Your ref: 3/2020/0308

Date: 30th September 2020

Planning Application 3/2020/0308: Repairs to south-western outshut roof to remove existing roof covering; replace rotten timber trusses with equivalents; re-covering roof with breathable membrane; fitting new softwood battens and re-roofing with set-aside roof slates.
Hall Barns Farm, Knowles Brow, Hurst Green BB7 9PT

**PROPOSED PLAN AND ELEVATIONS  
INDICATIVE SECTION**

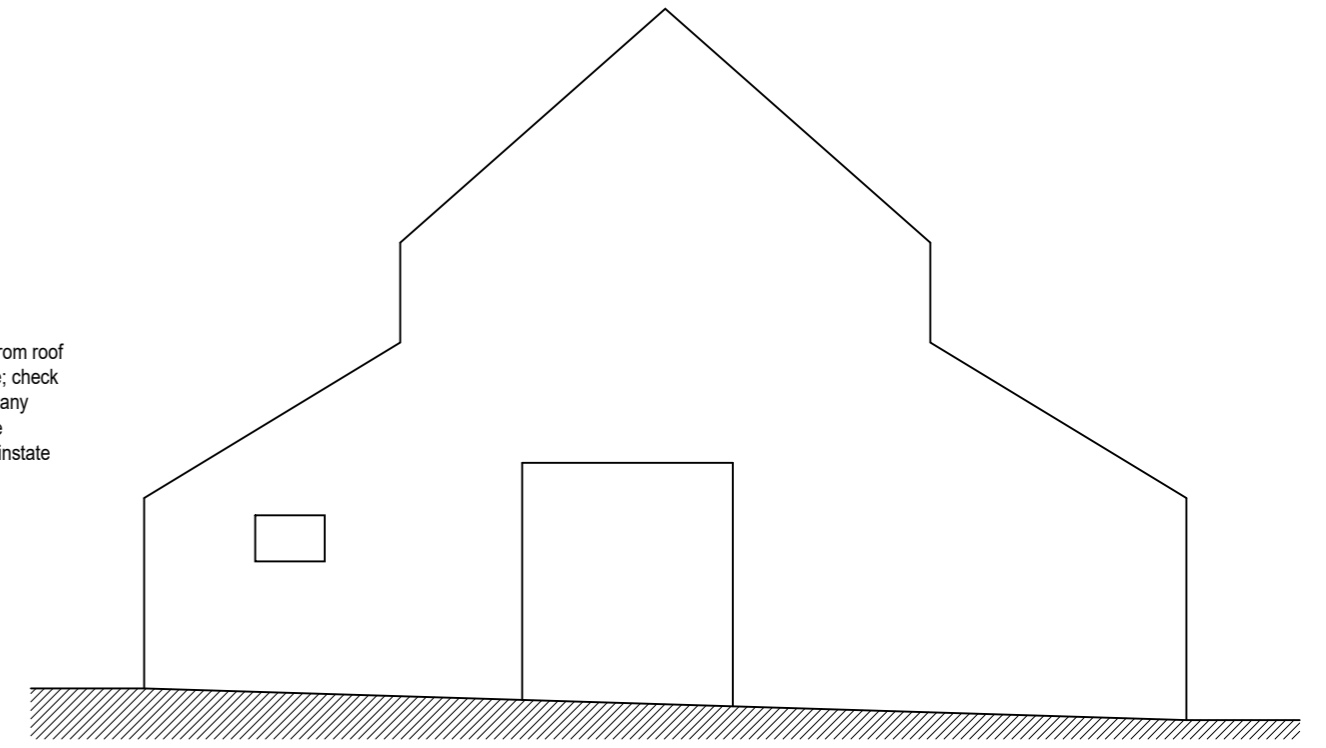
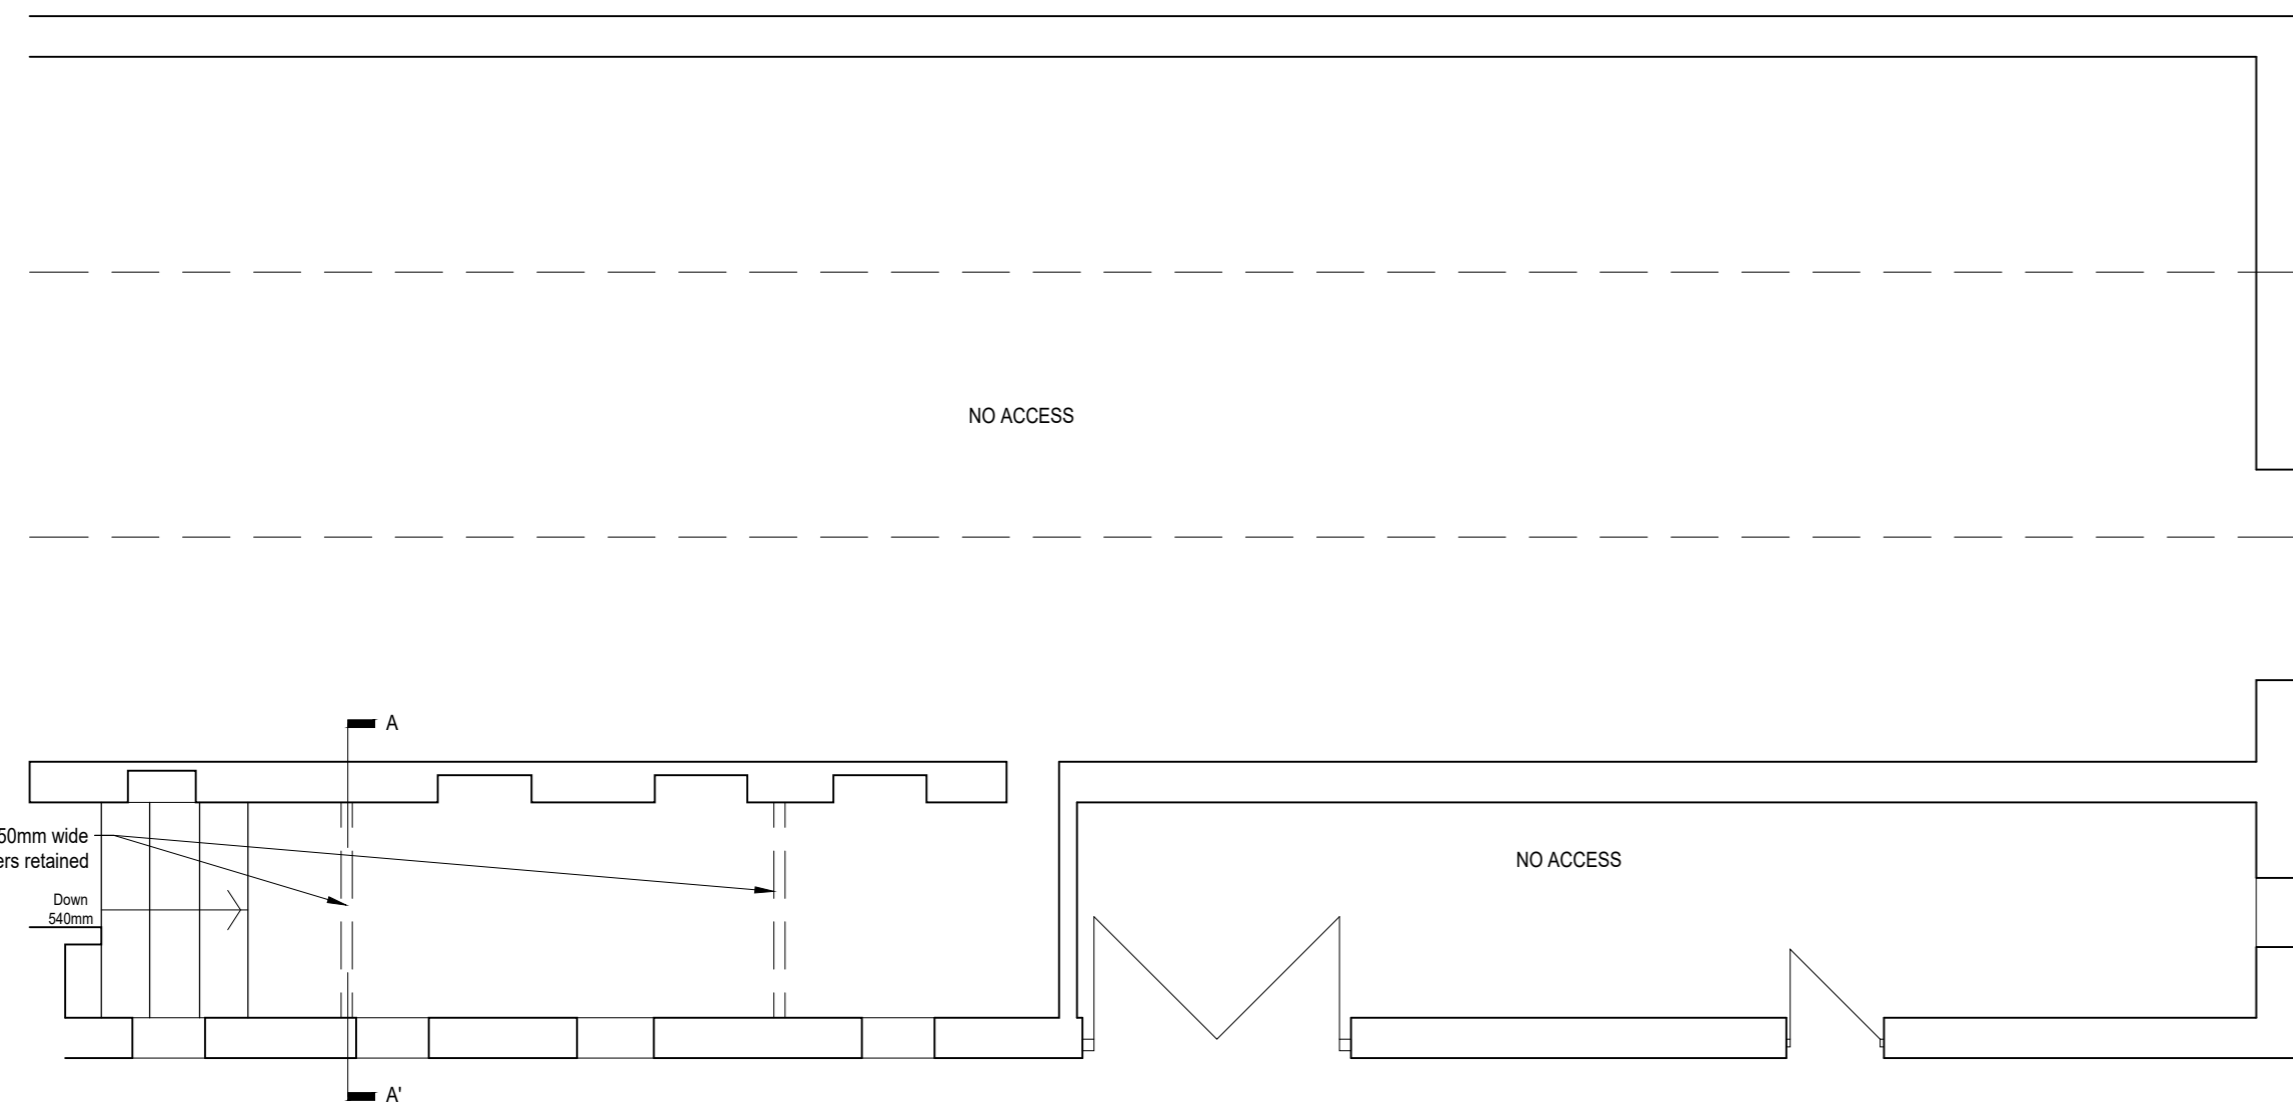
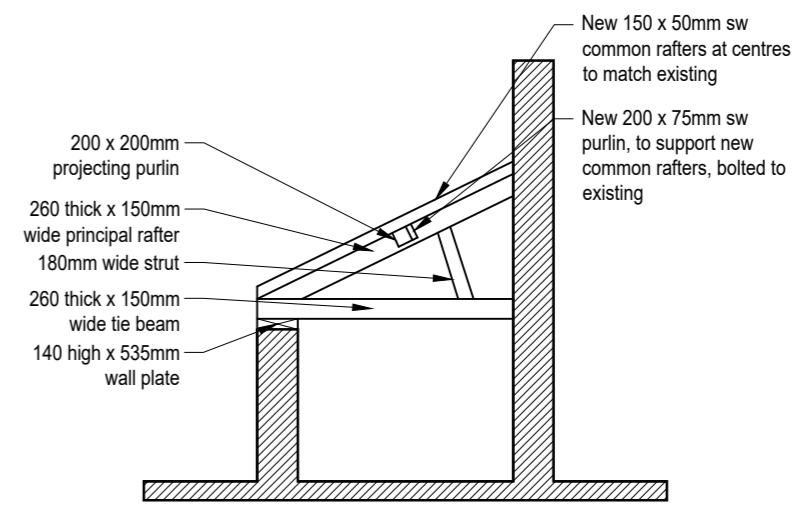
A problem with application is in the description of the proposed works. In the application itself a major element is "... *replace rotten timber trusses with equivalents* ...", whereas the schedule of works from Carter Jonas (June 2020) only mentions fitting new common rafters and battens. Neither of these mention replacement purlins, although the photographs in the Heritage Statement shows that they are missing in at least a portion of the outshut and that at least one truss appears to have been removed (an empty corbel appears in Plate 29). It may of course be that the purlins and the truss have merely been taken down and stored, along with the slates. It may also be necessary for the wall plate to be repaired or replaced. The full scope of the work needs to be established and set out clearly in one document for formal approval. We would have no objection to the replacement of such wooden items as are strictly necessary, although as much of the originals should be retained as is practicable and an appropriate condition assessment justifying the work also needs to be supplied.
